From: patrickprendergast@bucksplantcare.co.uk
Sent: 04 November 2021 10:59
To: James Kirkham
Cc: Jonathan Emanuel
Subject: RE: Planning notification for application reference: 21/01123/F

I am commenting on the above application from an arboricultural aspect.

Proposal – Construct replacemnt buildings

DRAWING TITLE	- Proposed Site Plan - Overall		
CONTRACT	- The Hatchery		
MODELLED BY	- HS	ISSUE DATE	- 10.09.21
CONTRACT NO	- JOB139990	SCALE	- 1:500 @A1
DRAWING No	- 139990_P102	REVISION No.	E

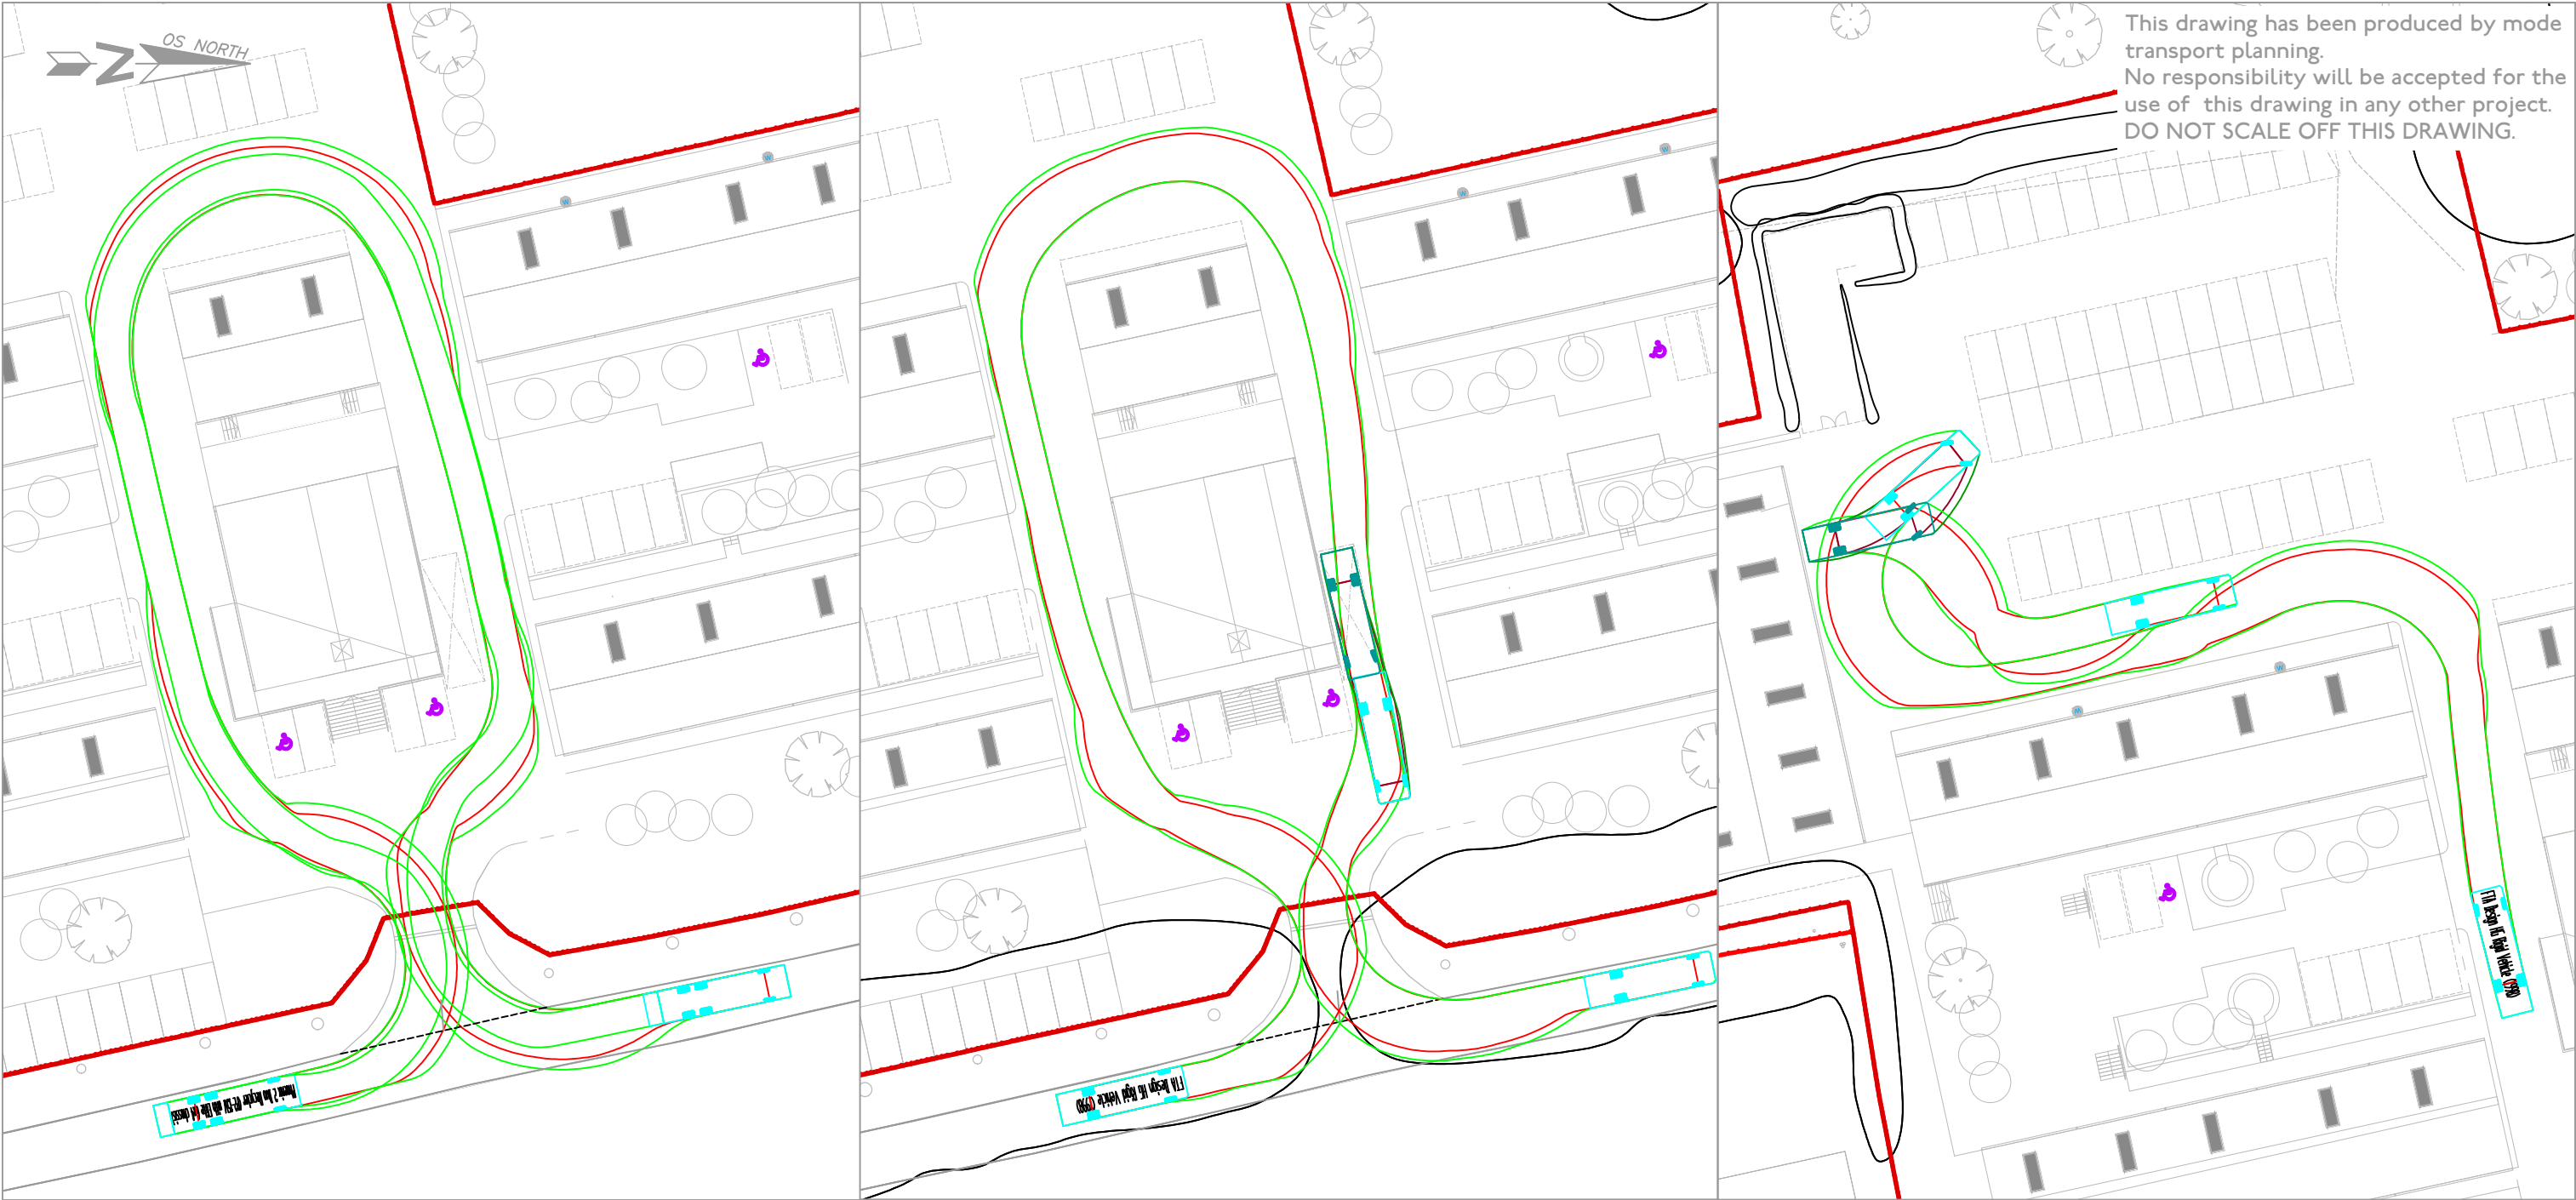
So an updated Arboricultural report is required and you can make a comment about the proposed parking under lime trees which will be dropping honey dew.

Thank you for your comments on this. I have just noticed that the Tree retention and protection plan appears to be based on the old layout. The new layout of the site now includes parking under the large lime trees on the eastern boundary (if you look at the overall site plan). Could you please clarify if this alters your comments or if you are satisfied the parking can be provided without damage to the trees?

Also do you have any concerns placing parking under lime trees leading to long term pressure for removal? My understanding is these trees can result in sticky residue.
